Our ref: NO/2012/104629/02-L02
Your ref: 3/2012/1042
Date: 25 March 2013

Our ref: NO/2012/104629/02-L01
Your ref: 3/2012/1042
Date: 25 March 2013

**PROPOSED CHANGE OF USE FROM VACANT SHOP PREMISES AND DWELLING
TO FORM 2 NO APARTMENTS
2 WALKER STREET, CLITHEROE**

drawing title
SCHEME DRAWING
PLANNING APPLICATION

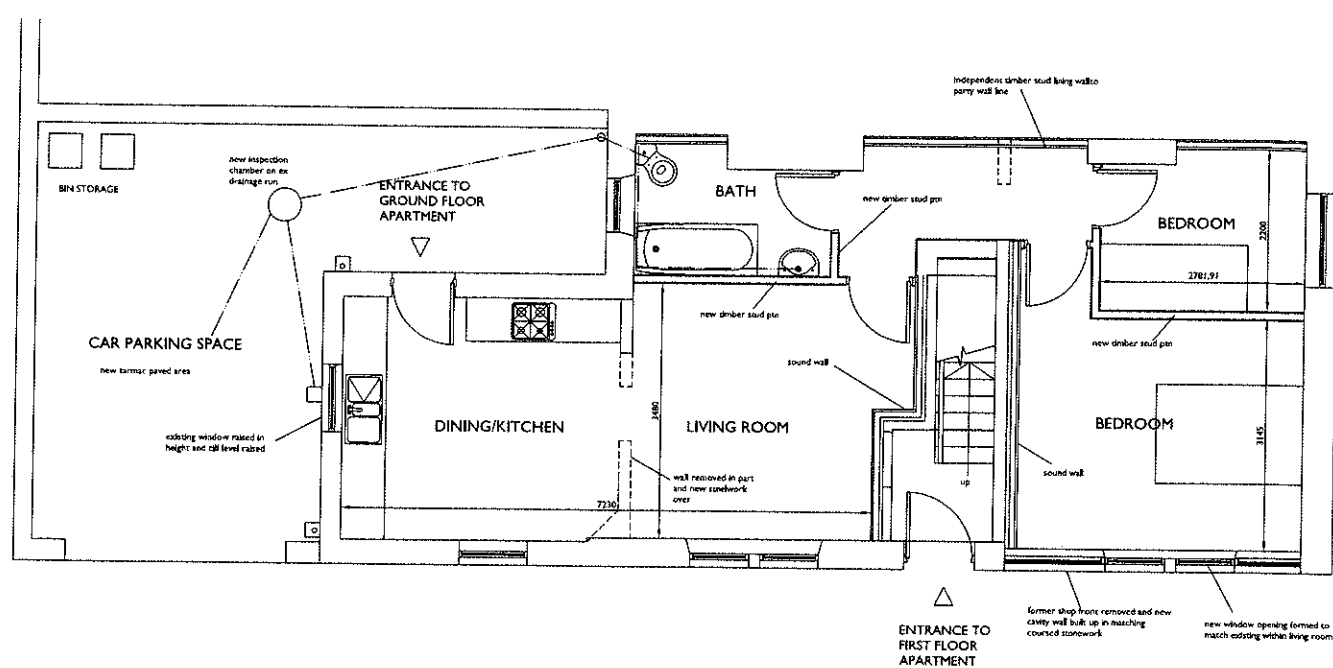
As discussed, the site is located in Flood Zone 3, which is defined as having a high probability of flooding. Based on the information you have submitted, the existing ground floor level of the property is 74.93 metres AOD. The predicated 1 in 100 year flood event for the site is 75.57 metres AOD suggesting a potential depth of flooding of up to 600mm within the proposed ground floor apartment during an extreme flood event.

Given the nature of the proposed development, we are concerned that any future occupants of the ground floor apartment would be at an unacceptable risk of flooding and they would have no safe point of refuge. We do not feel that the provision of a 600mm step into the apartment would mitigate the risk. If the application was resubmitted in its current form, we would object to the proposal on the grounds that future occupant(s) of the ground floor apartment would be at an unacceptable risk during an extreme flood event.

To resolve our objection, we would recommend that the applicant considers converting

the shop to a single dwelling or it may also be possible to consider a pair of duplex style apartments with dining/living accommodation at the ground floor and sleeping accommodation at first floor. This would resolve the flood risks associated with living in a ground floor dwelling while still ensuring this Brownfield site can be brought back into use. Flood proofing of the ground floor would still be recommended as part of any subsequent proposal and should be detailed in a FRA appropriate to the nature and scale of the development.
